File No: NTH10/00161/10

Your Ref: 11_0047 Mod 6 and 10_0015 Mod 4

Environmental Assessment – Modification to Project Approvals – Increase Annual Road Transport Tarrawonga Coal Mine (11_0047) and Rocglen Coal Mine (10_0015)

*Modification Assessment  
(11\_0047 MOD 6 and  
10\_0015 MOD 4)*

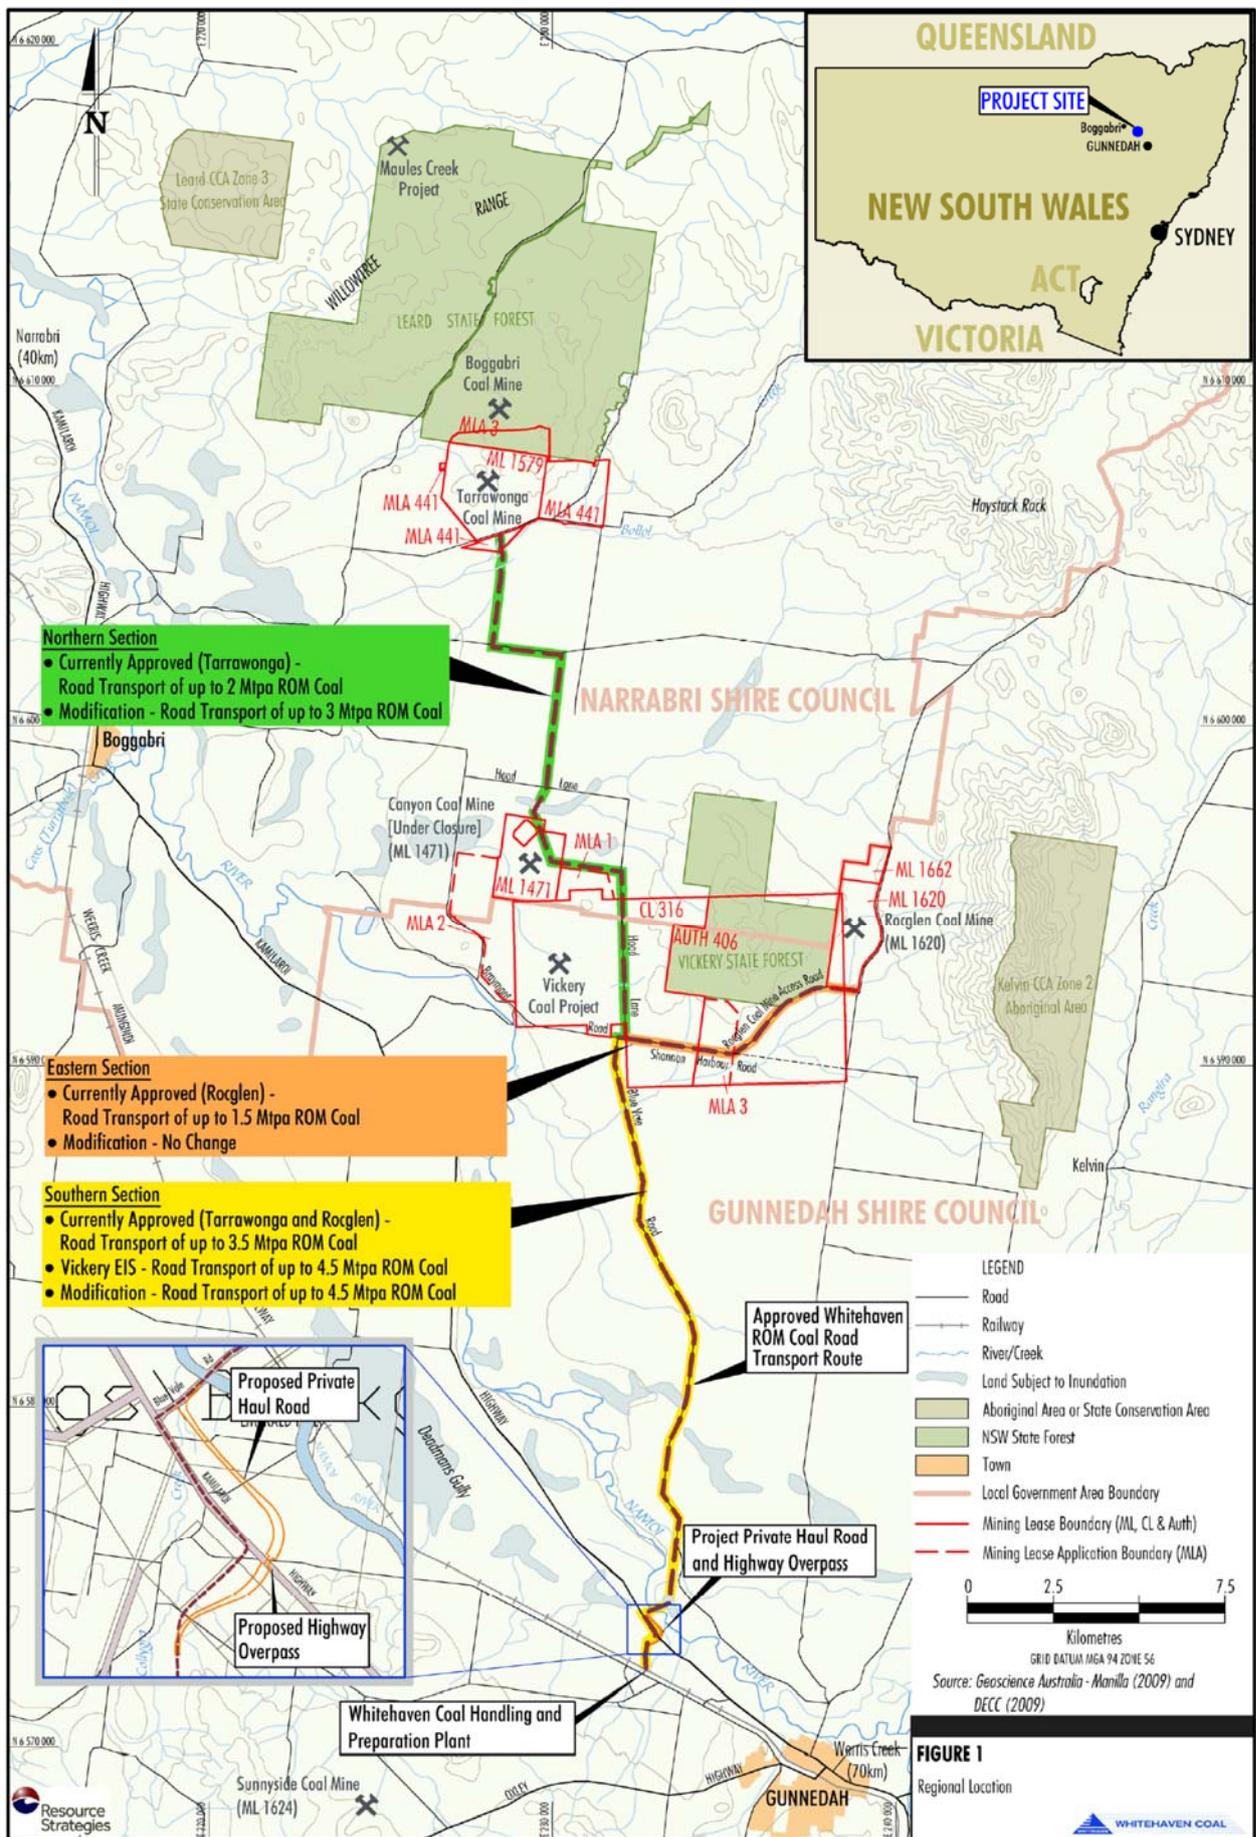
3. Based on recent onsite investigations and consultation with Gunnedah Shire Council, Roads and Maritime requests asphalt concrete resurfacing of the Kamilaroi Highway between the Blue Vale Road and Whitehaven Coal Handling and Processing Plant (CHPP) be undertaken as a condition of the approval.

Any works on the Kamilaroi Highway must be designed and constructed in accordance with the current Austroads Guidelines, Australian Standards and RMS Supplements.

The Developer would be required to enter into a Works Authorisation Deed (WAD) with Roads and Maritime for any works deemed necessary on the classified (State) road network. The developer would be responsible for all costs associated with the works and administration for the WAD.
